**Application Reference:** 2025/0374

**Location:** 3 Whitehill Avenue, Pogmoor, Barnsley, S70 6PP.

This application seeks planning permission for the erection of a wrap-around extension comprising a two-storey side extension and single storey rear extension.

Drng. no.	Rev.
305-25-PL02	C

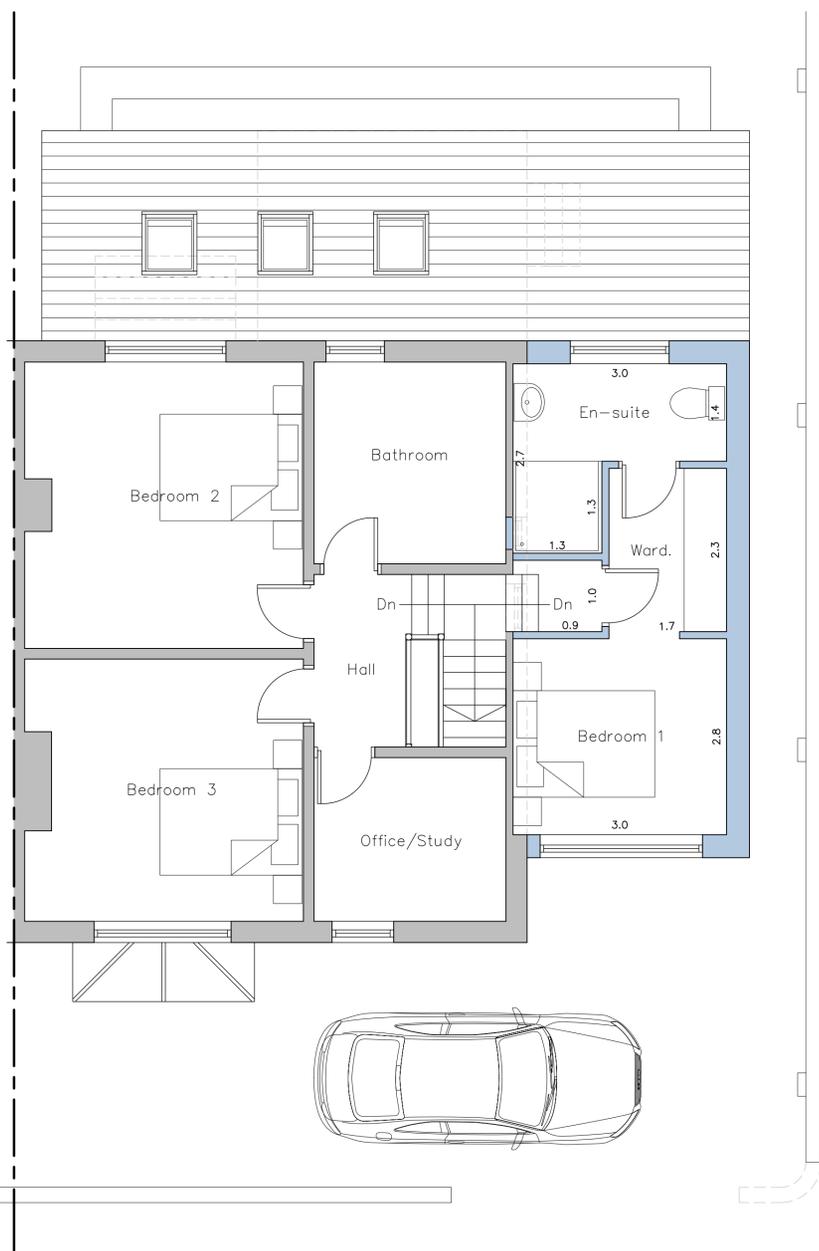
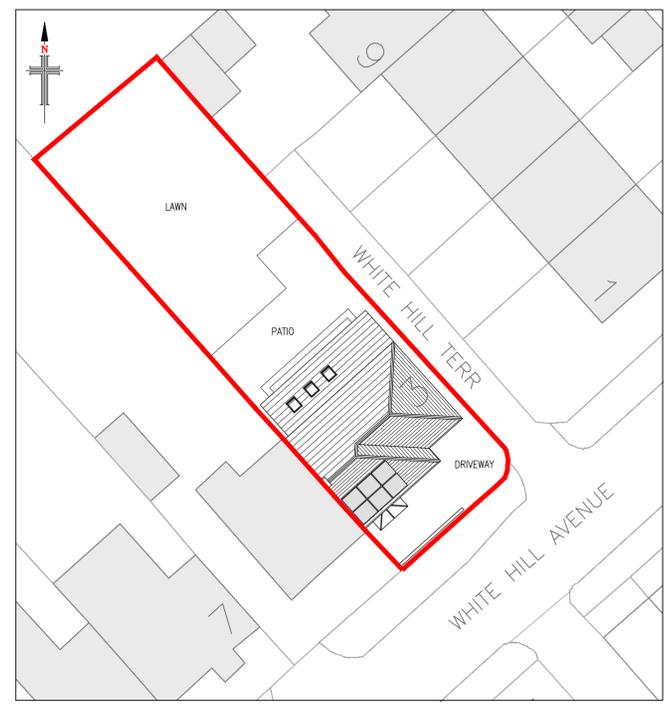
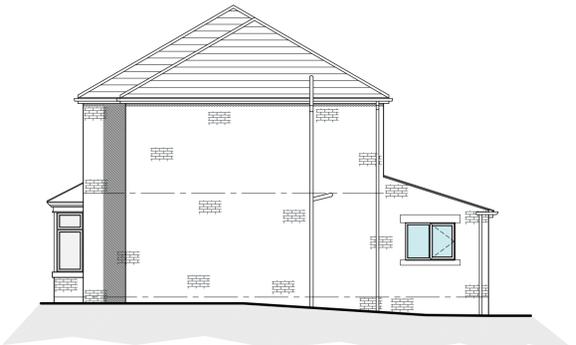
During the application process, the proposal was amended to maintain a second off-street parking space within the application curtilage and to remove part of an existing boundary wall for access and egress.

New first floor windows would be limited to the front and rear elevations of the proposed two-storey extension. A sufficient separation distance (21 metres or more) would be maintained to the rear. The separation distance achieved to the front would be approximately 18.2 metres. It is acknowledged that this would be less than the 21 metres normally required. However, the proposal would achieve a greater separation distance than exists, which on balance, is therefore considered acceptable in this instance. A sufficient separation distance (21 metres or more) would also be maintained between

Regarding outlook, approximately 11.9 metres would be achieved between the blank gable elevation of the proposed two-storey extension and neighbouring habitable room windows. It is acknowledged that this would be less than the 12 metres normally required; however, the approximate 0.1 metre difference is not considered to be material and would not significantly adversely affect the amenity of the occupants of neighbouring properties.

The proposed two-storey extension would adopt a sideways projection more than half the existing width between the original dwelling and the side boundary, contrary to the adopted design guidance within the House extensions and other domestic alterations SDP. However, the proposed two-storey extension would not adopt an excessive sideways projection of more than two thirds the width of the original dwelling, it would be set back from the front elevation by approximately 1.3 metres and would be set below the existing ridge line, in accordance with adopted design guidance. It would also adopt a sympathetic form and features, including a hipped roof and closely matching external materials. It would appear subservient and would not significantly alter or detract from the character of the street scene.

The proposal is not considered to be prejudicial to highway safety; an integrated garage is included which would be sufficiently sized to be counted towards the off-street parking provision. An additional space would be created to the front of the application dwelling within the site and part of an existing boundary wall to the front would be removed to enable adequate access and egress. The proposal was amended to address Highways comments. Highways Development Control were consulted on the amended proposal, and no objections were received subject to conditions.

- The provision of two off-street parking spaces within the application curtilage.

305-25-PL02 Rev. C received 11<sup>th</sup> June 2025
